From: Chris Moore <[REDACTED]>
Sent: 15 August 2019 17:57
To: Maria Tomalova <Maria.Tomalova@arun.gov.uk>
Cc: [REDACTED]
Subject: RE: BR/154/19/PL, 8 Mead Court

From: Maria Tomalova [<mailto:Maria.Tomalova@arun.gov.uk>]
Sent: 15 July 2019 16:13
To: [REDACTED]
Subject: BR/154/19/PL, 8 Mead Court

SITE PLAN - 1/500

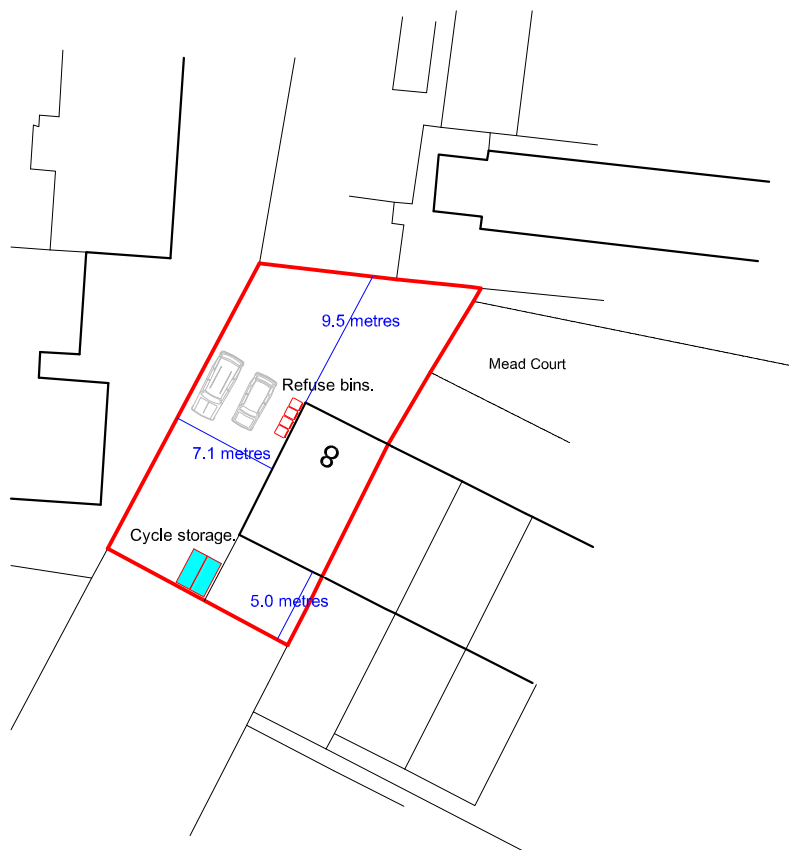
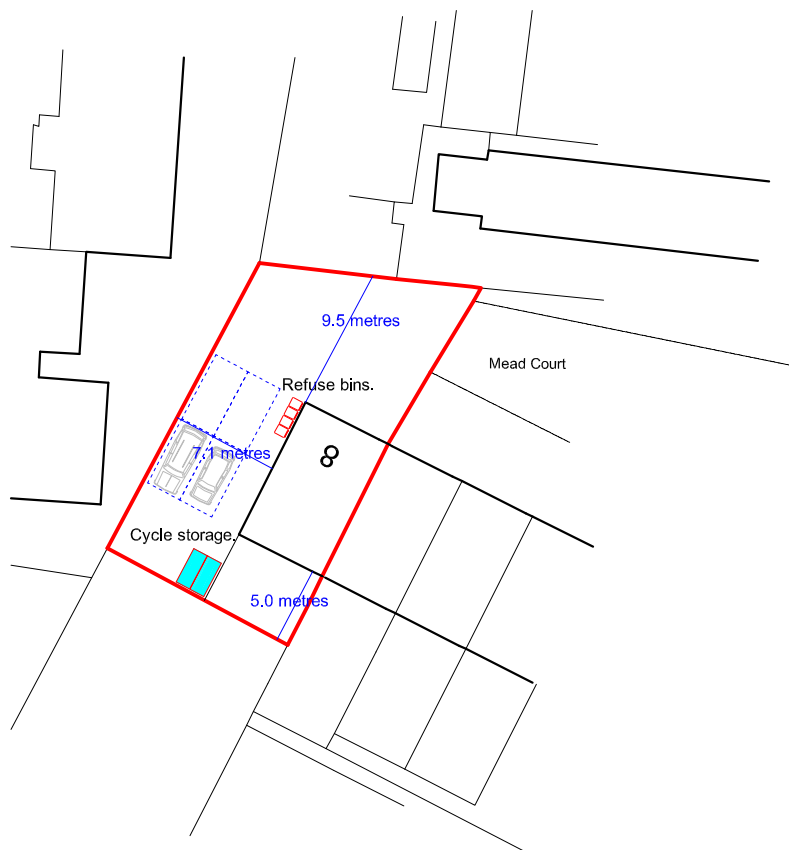
You have probably spotted that the above application has been objected by the Bognor Regis Town Council as such if we want to support it, it should be decided by the Committee.

One of the grounds was a lack of parking spaces provided.
I have been on the site and the site is big enough to accommodate 4 cars,
What is a requirement for 8- bed HMO.

It would be helpful if you can demonstrate the provision of 4 parking spaces.

The site as you will know is more than capable of taking twice the amount, however, I attach a copy of a revised site plan indicating 4 x spaces as requested -- I trust that this is ok?
